**A1 Birtley to Coal House**  
**Scheme Number: TR010031**

**Applicant's Response to ExA's Fourth Written**  
**Questions**

**Applicant's Response to ExA's  
Fourth Written Questions**

<b>Version</b>	<b>Date</b>	<b>Status of Version</b>
Rev 0	13 July 2020	For Issue

B2CH							
Section	Type	ID	Direction	Type	Role	Number

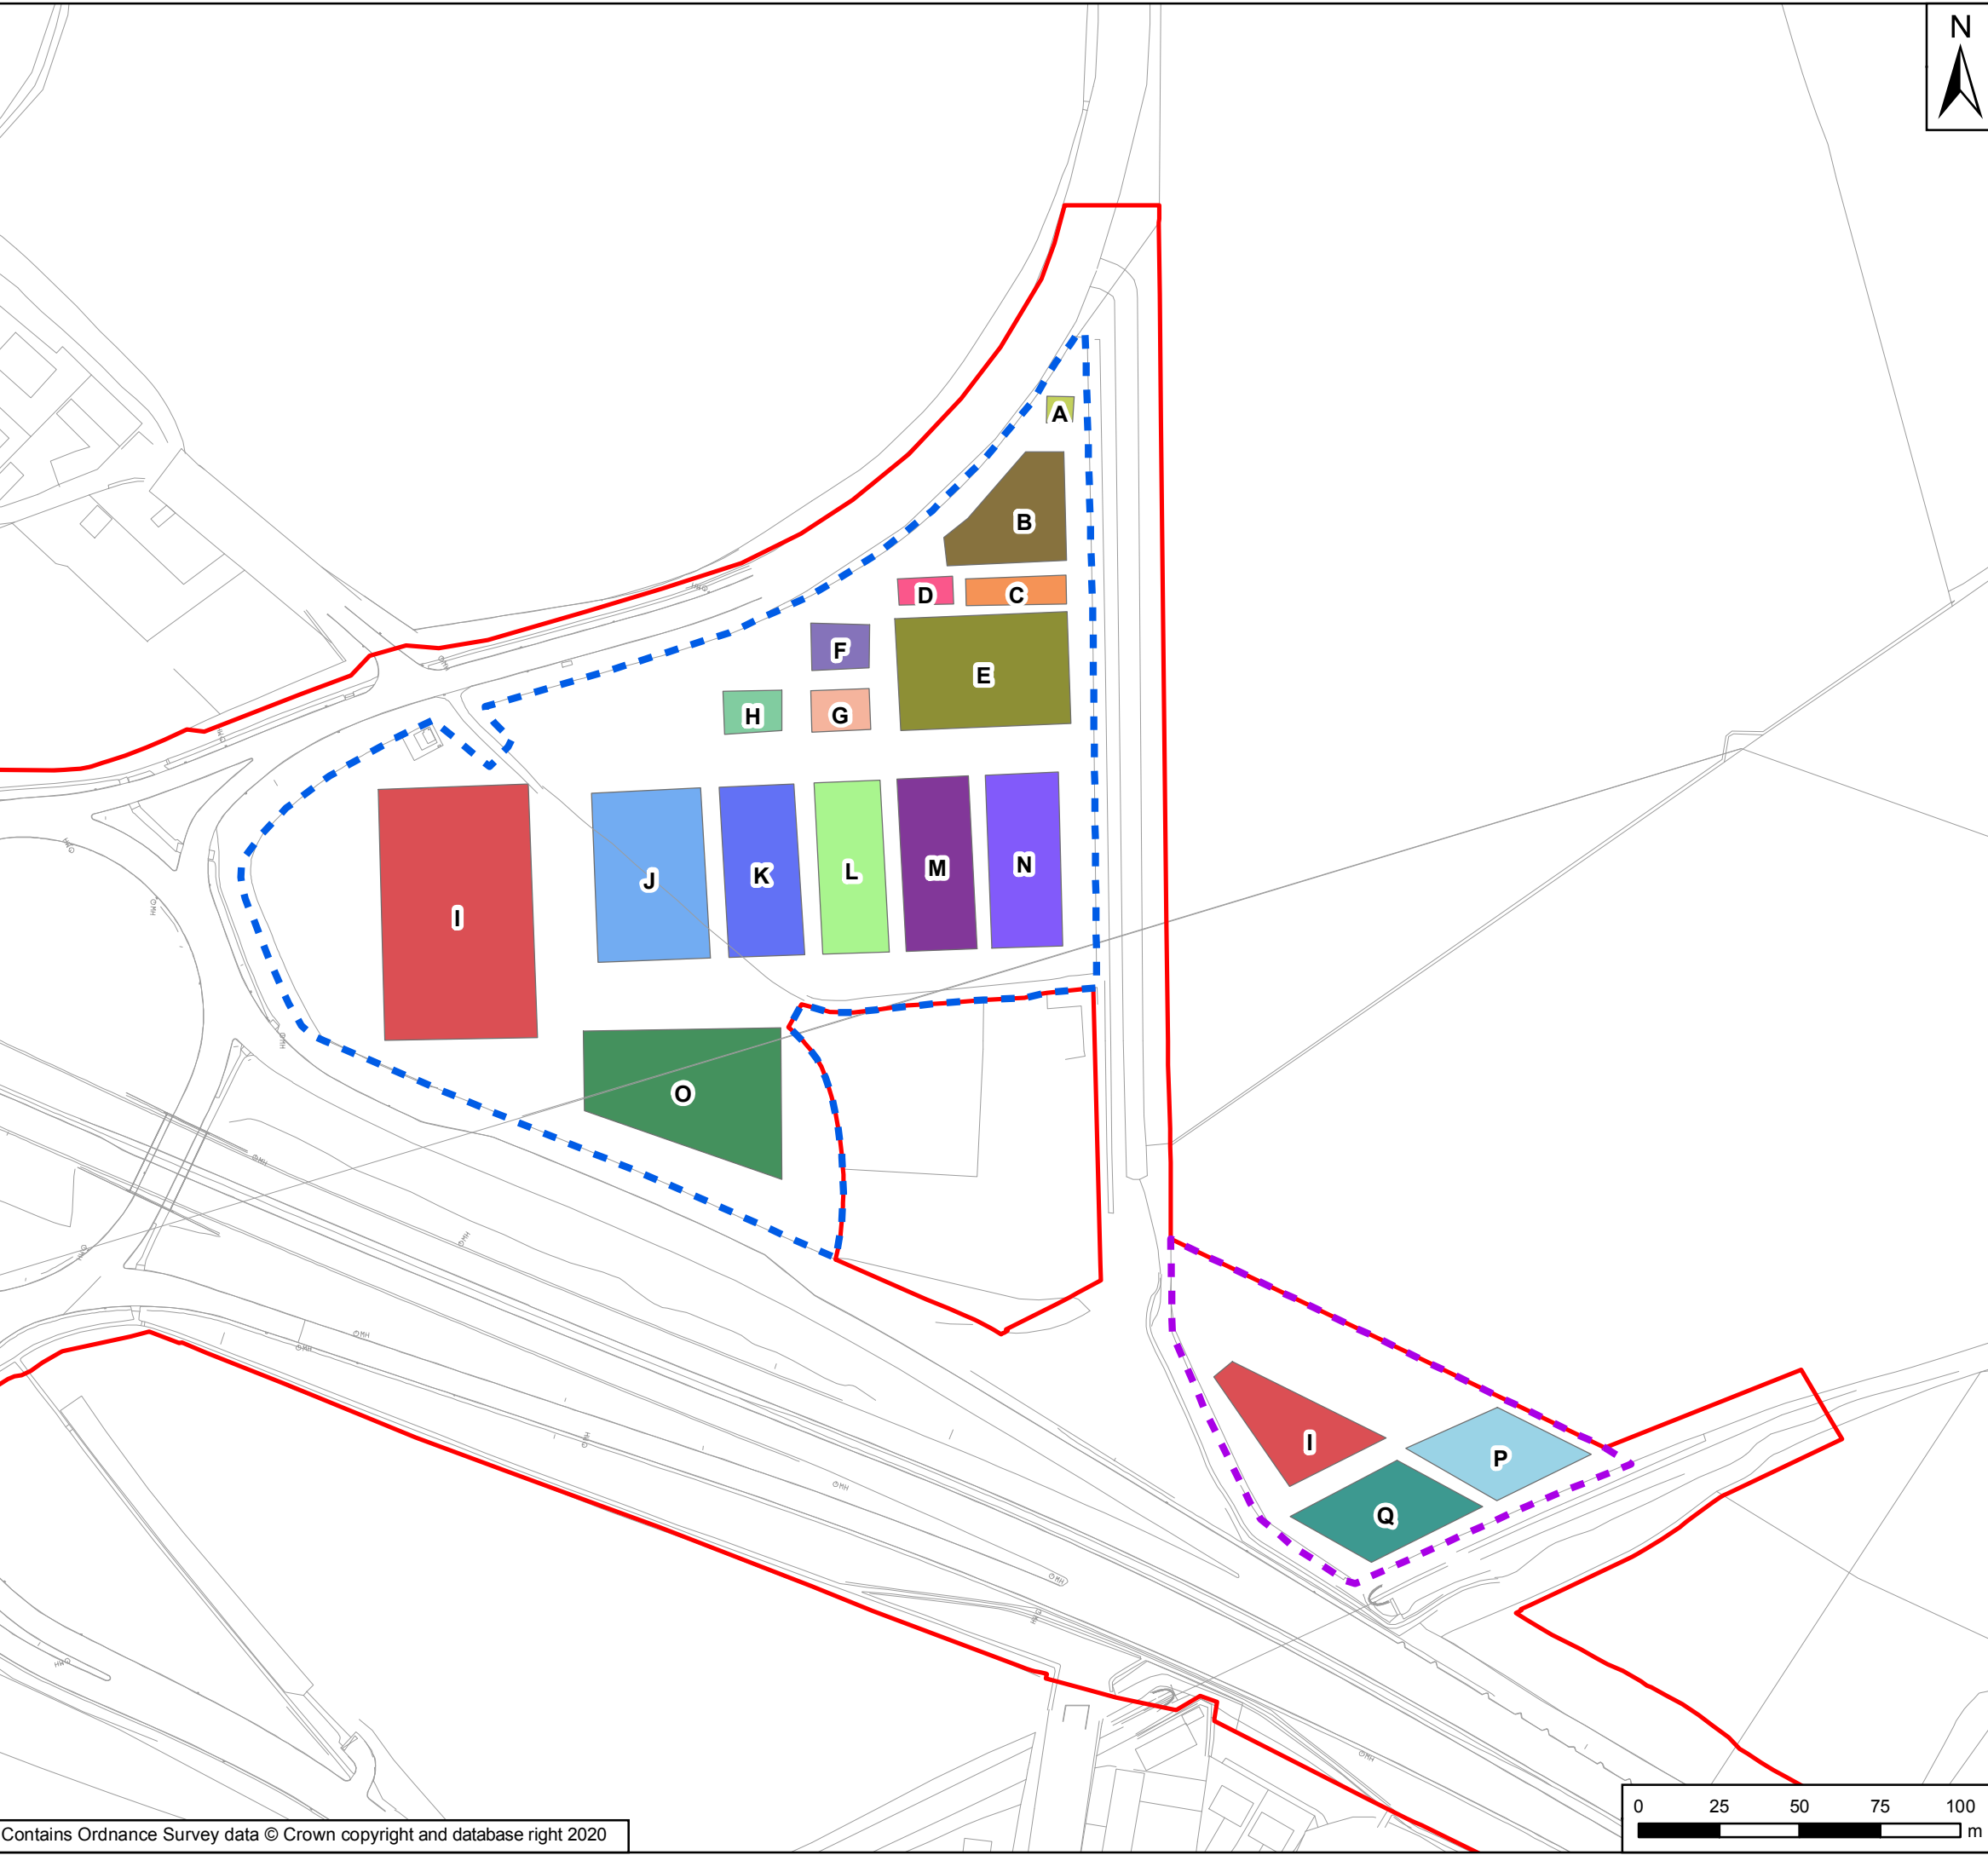
Ex Q4:	Question to:	Question:	Applicant's Response:
4.1.1	Applicant	<p>Figure 1/AI Site Compound Plan Detailed View, Junction 67 (Additional Land) of Appendix A of the Construction Environmental Management Plan [REP8-007] shows what appears to be areas of spare (white) space with the northernmost part of the compound, with no designated use. Given the amount of space that appears not to be required for any designated use or purpose within the compound, how can the Secretary of State be satisfied that the amount of land proposed to be acquired is no more than is reasonably required?</p>	<p>The absence of a designated use is not evidence of the absence of use for the land in question. It is the Applicant's case that all land within the Order limits is required for the delivery of the Scheme. It may comprise working areas or circulation space.</p> <p>The "white space" that the ExA has identified is necessary for the delivery of the Scheme as a whole. In the first instance, the land in question will be used for the delivery of Work No 12, being the replacement installation for Northern Gas Networks (NGN). The works in question would either be used by NGN itself or by the Applicant to deliver those works.</p> <p>When the main works are programmed to commence, that part of the site is likely to be required for the NGN works for some seven months thereafter. That part of the site will essentially be sterile and the Contractor implementing the Scheme on behalf of the Applicant will not be able to use it when works start. It will then be used to facilitate access to construct the new embankment/bridge and for storage.</p> <p>The proposed arrangement of temporary cabins, welfare parking, temporary plant and material located between the existing overhead 66kV power lines and the existing 900mm dia trunk water main also allows space to construct the proposed CNG terminal. On the plan, exclusion zones around the overhead service are shown as set out in GS6 of the Register of Environmental Actions and Commitments (REAC) in the Construction Environmental Management Plan (CEMP) [REP9-007 and 008] for working in close proximity of overhead lines.</p> <p>Therefore, when the programme of works for both the NGN diversion and above ground installation (Works No.9, 10, 12 to 16) and the construction of the highway elements of the Scheme are considered together, there is no 'white space' for the first seven months and that whole area will be occupied by either NGN or the Contractor implementing the Scheme on behalf of the Applicant.</p> <p>Once the NGN diversion is complete, the area in question will no longer be required and some of it, south of the track, would potentially be returned to pasture land. It is entirely reasonable to seek powers over the maximum area of land required because the construction sequence has been planned out so that both works for NGN and the A1 highway can be delivered to programme in compliance with CDM Regulations.</p> <p>There is no need for additional wording in the DCO to address this. It is appropriate to enable the Scheme to be delivered to include the whole of the land in question.</p>
